Your ref
Our ref PG/EVP/WS/3/35/8396
Date: 28 March 2012

APPLICATION NUMBER 3/2012/0099
MOOR HOUSE FARM, CLITHEROE ROAD, KNOWLE GREEN

It is proposed to erect a building as shown on drawing number 110B. The building would be divided into three main uses: a livestock housing area and wood store; two stables and a tack room; and a machinery/hay store with workshop.

0382 / 93 Drawing No 110 B

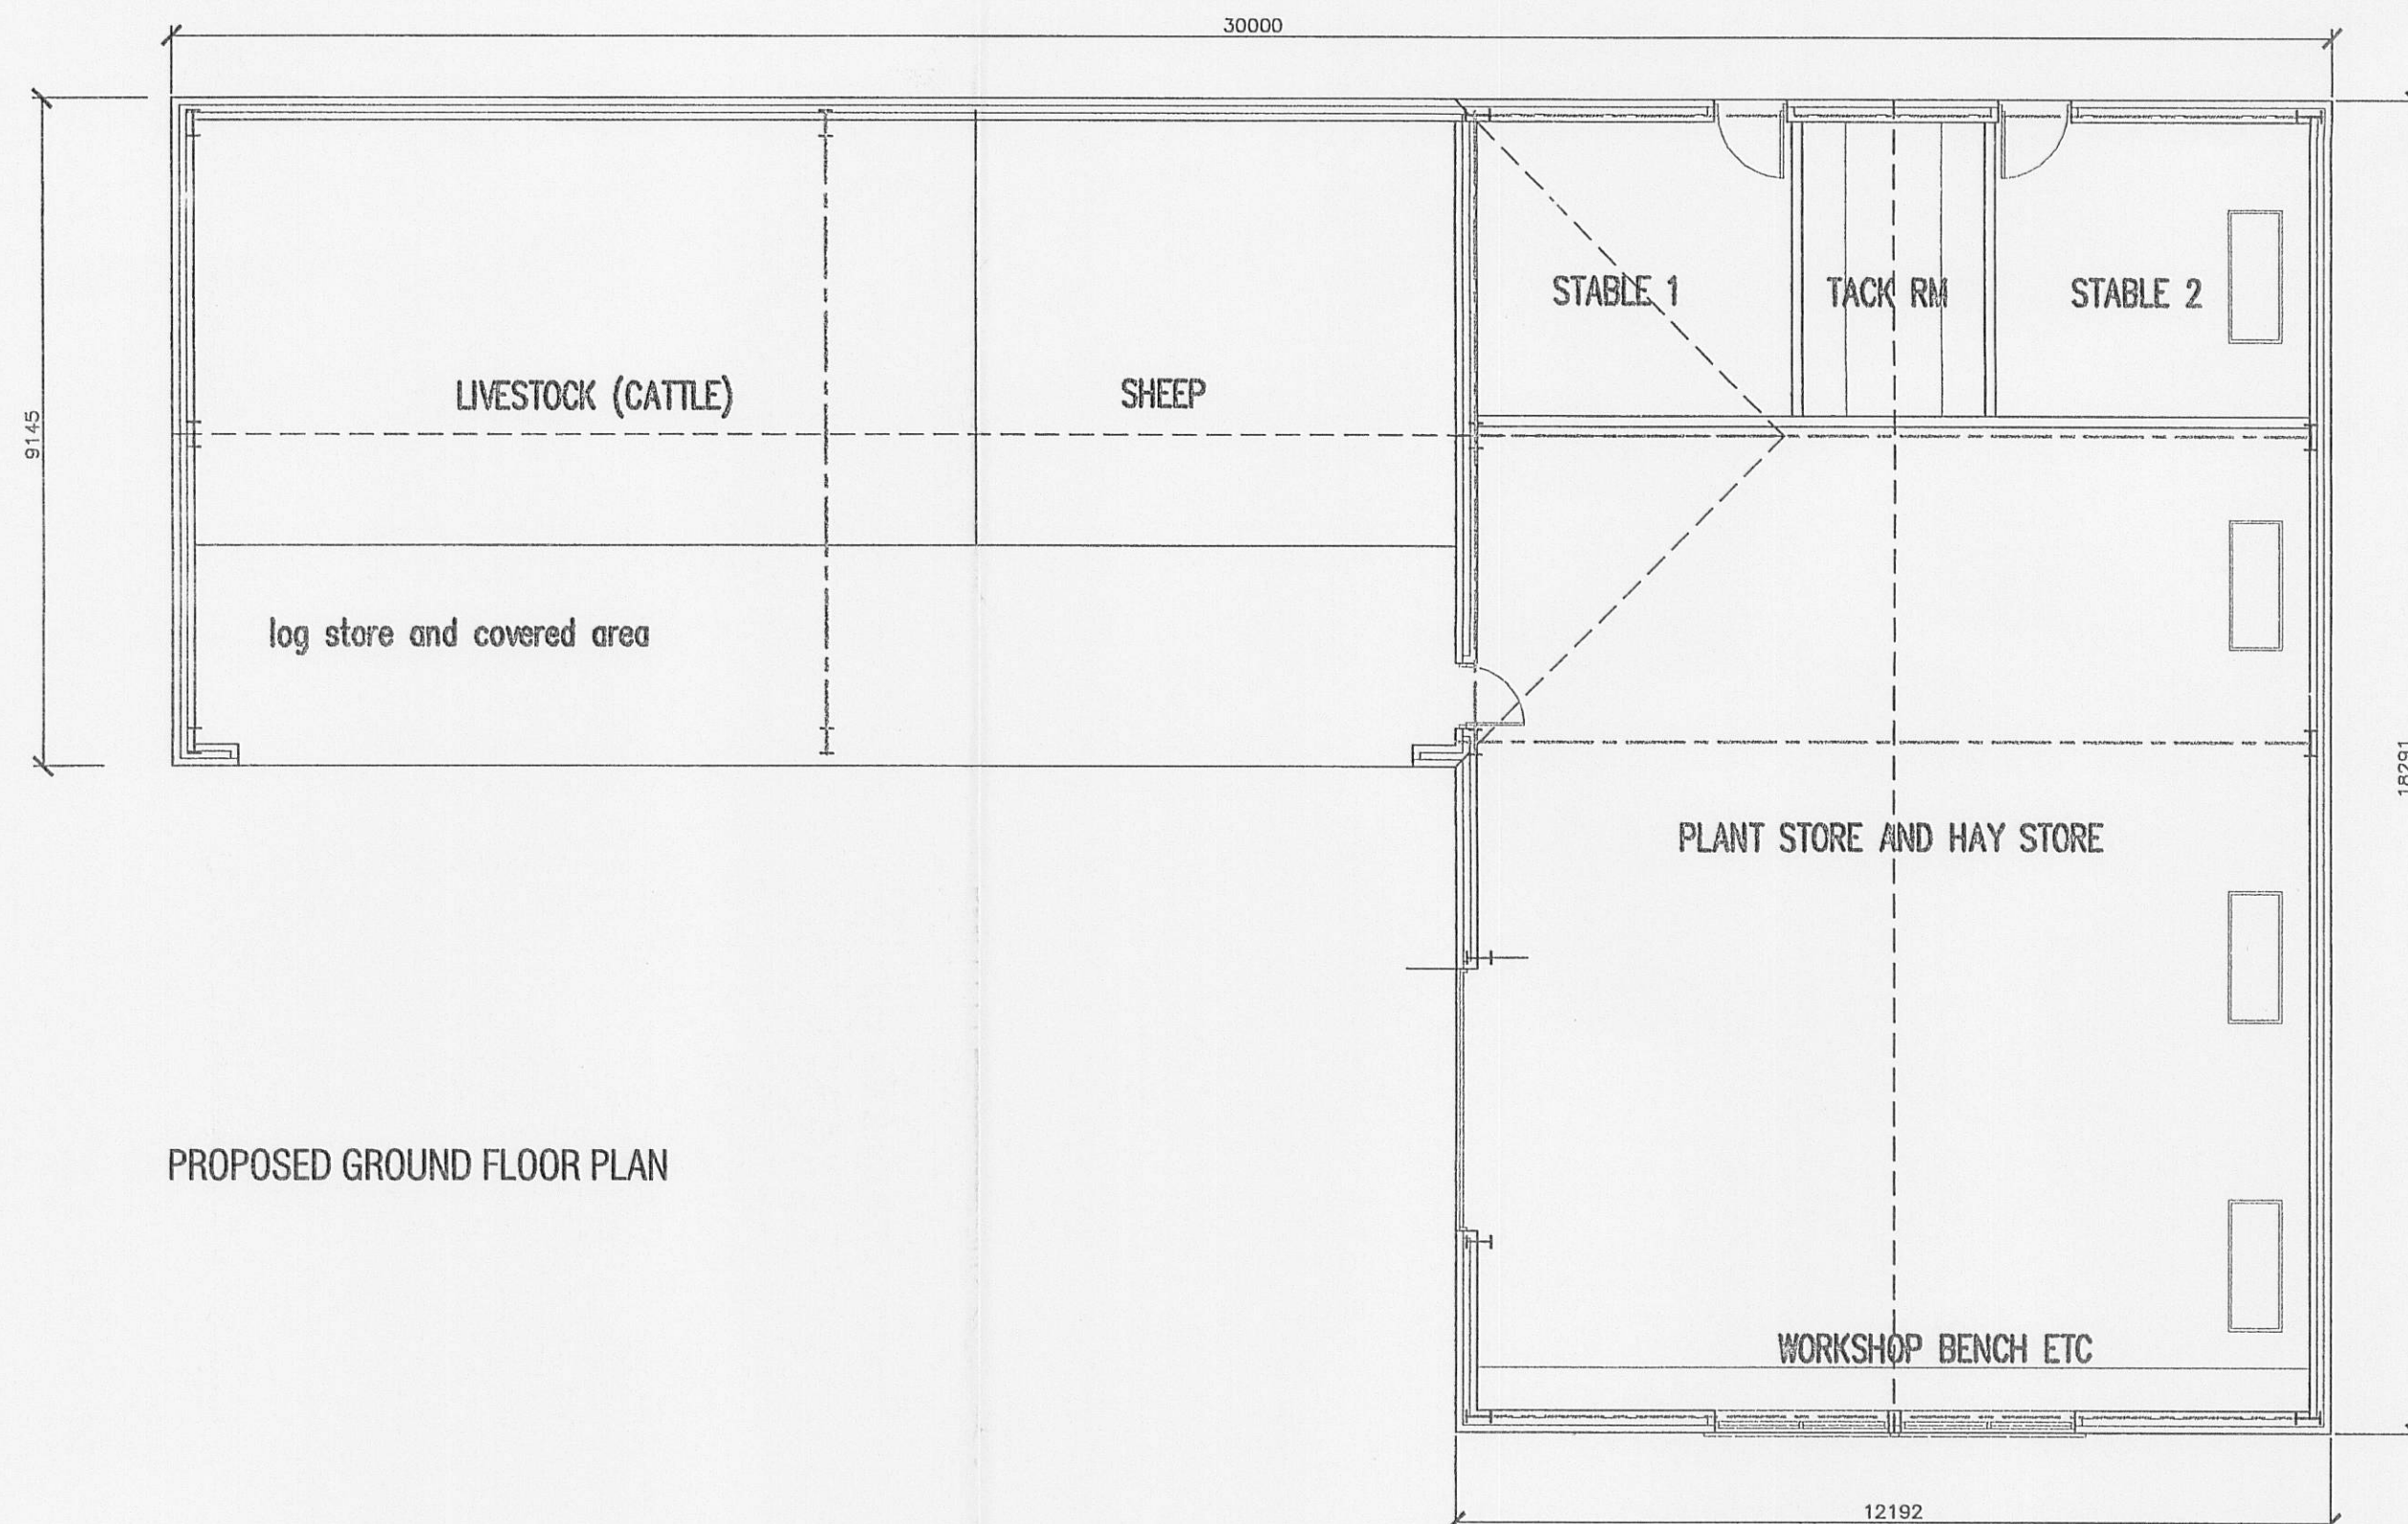
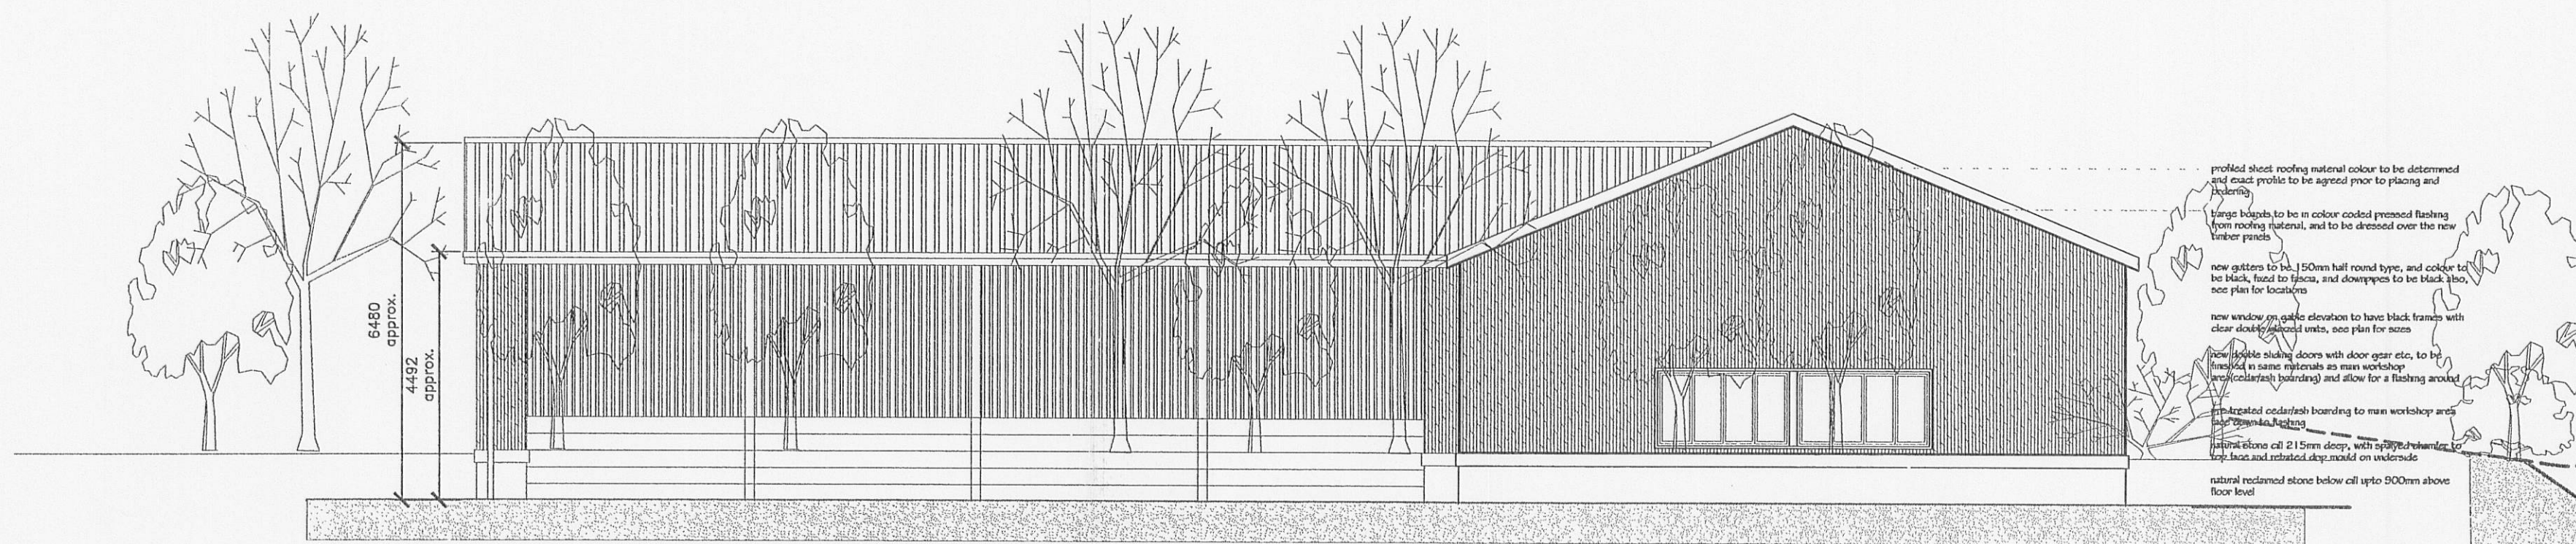
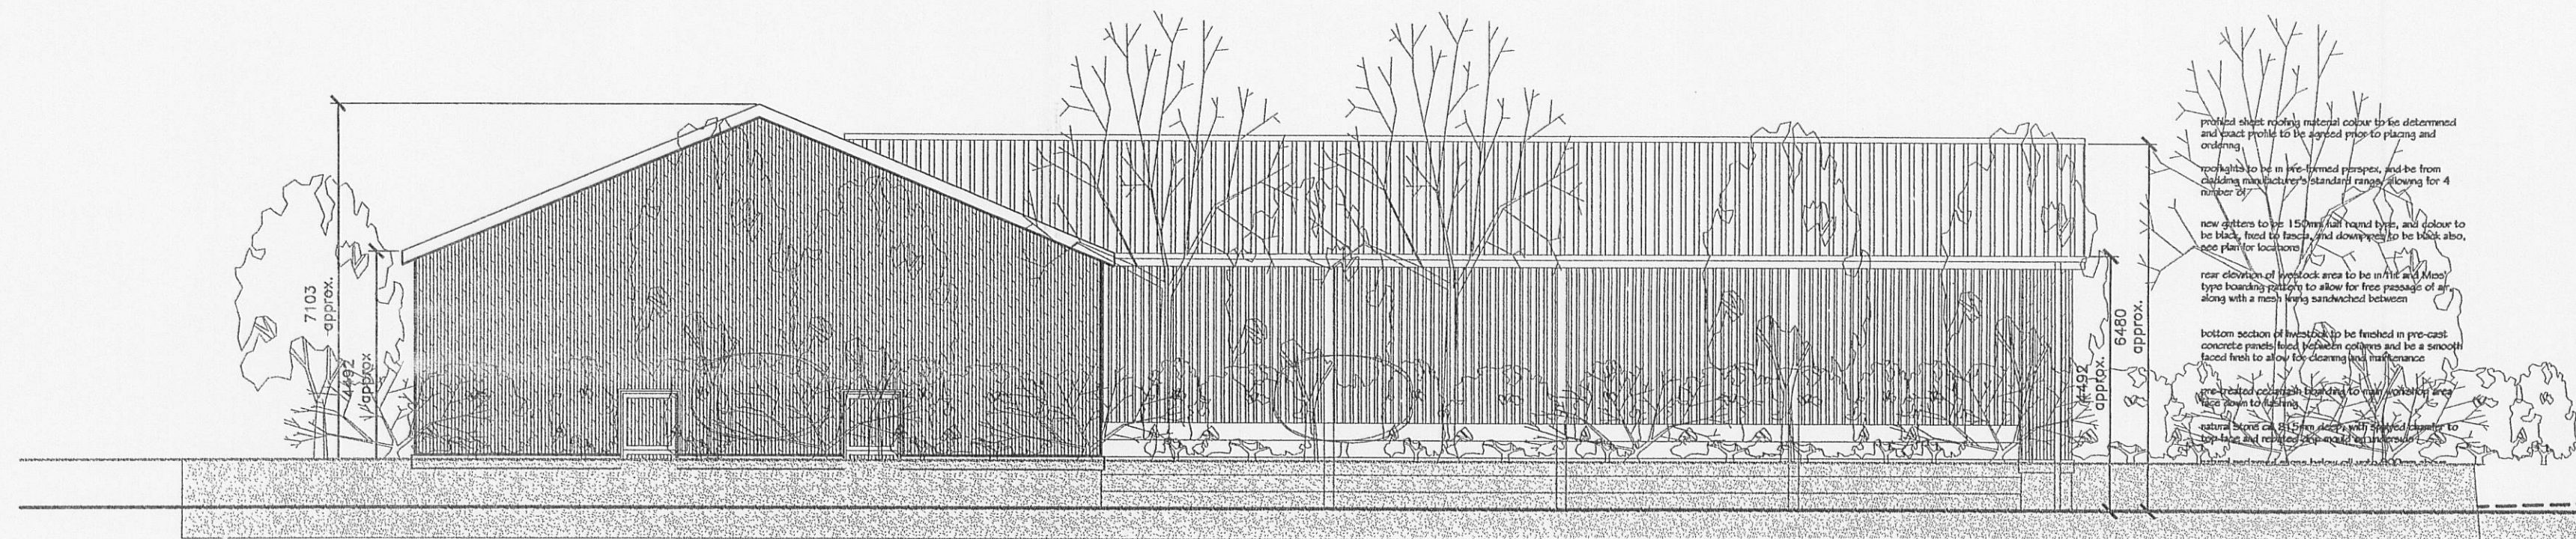
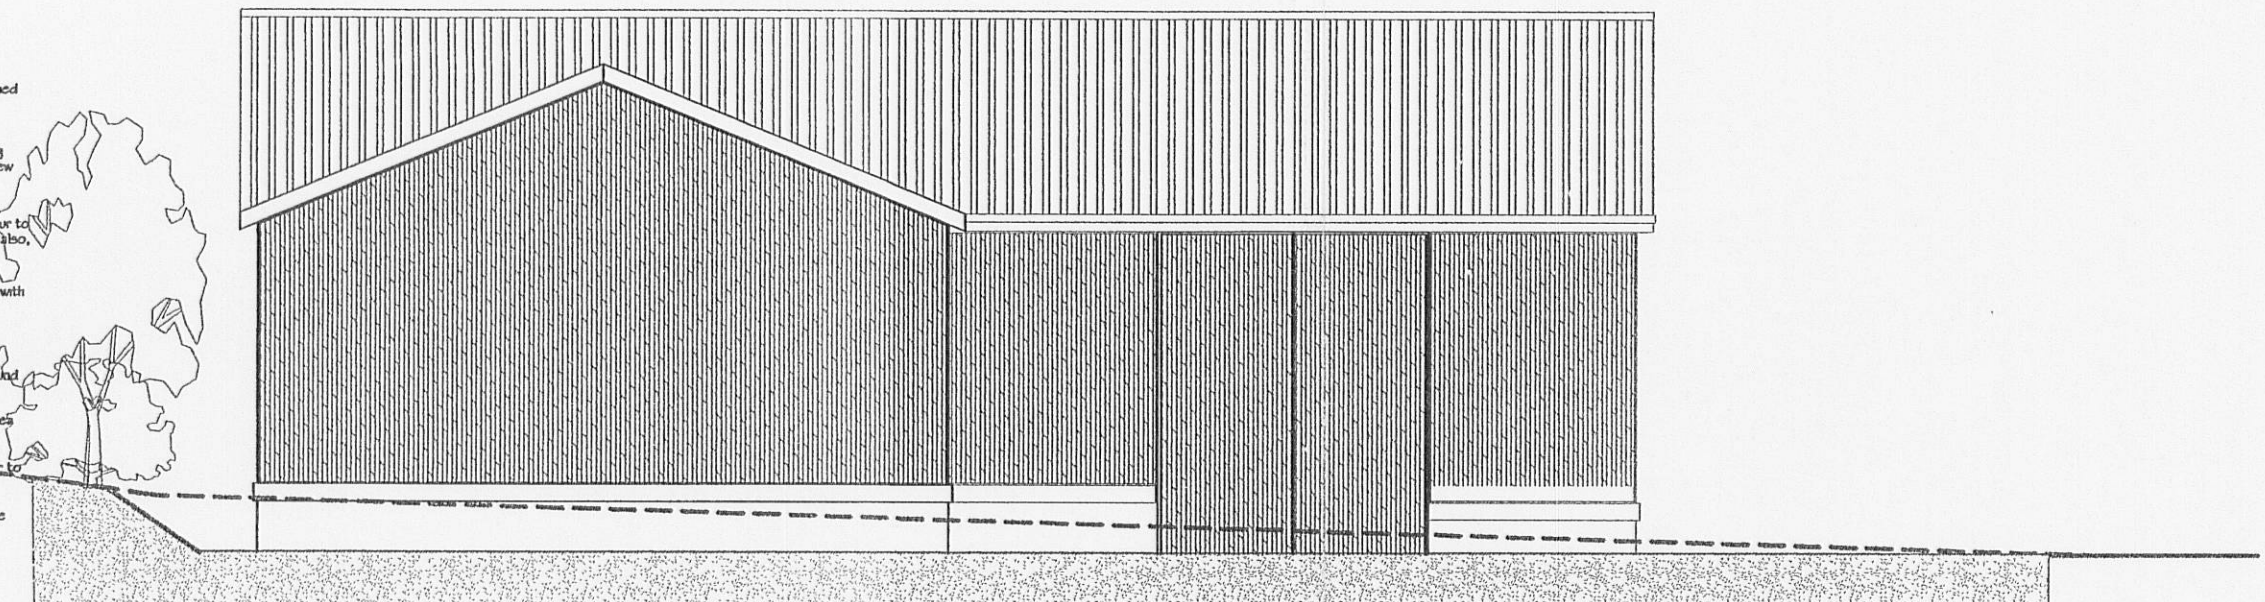
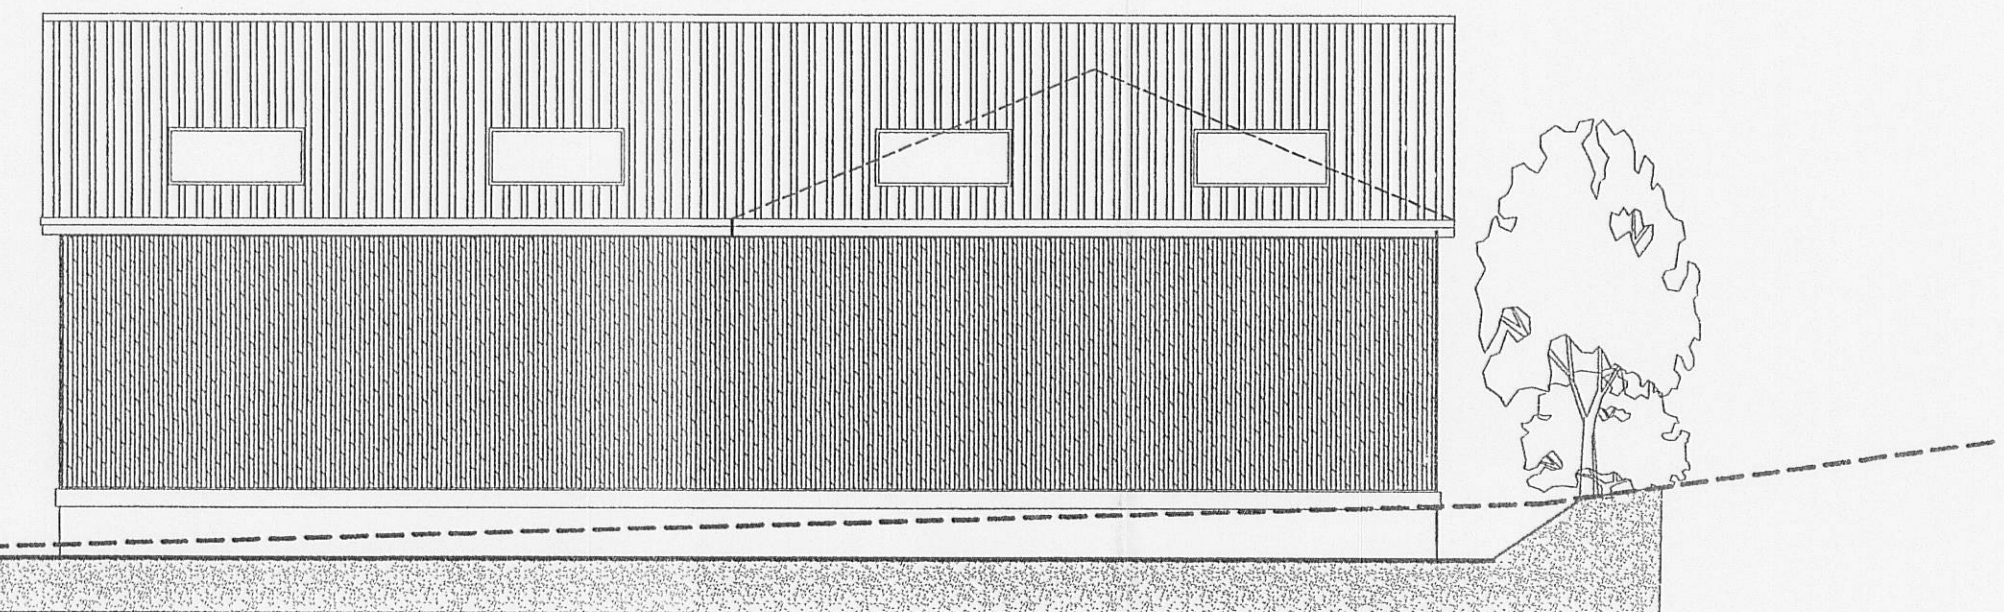
The scale of the proposed building is in my mind more akin to a facility that would be found on a larger unit e.g. high eaves height and the proposal for a workshop area. Also the proposed building does not appear to take into account the opportunity for dual uses and it should also be noted that the existing stone barn does provide some storage space. The general appearance/design of the proposed building is also not typical of an agricultural building i.e. concrete walling with Yorkshire boarding above with ease of access.

The proposed site of the building is some distance from the existing barn and house. Whilst the proposed site could be used, other sites closer to the existing buildings may also be suitable.
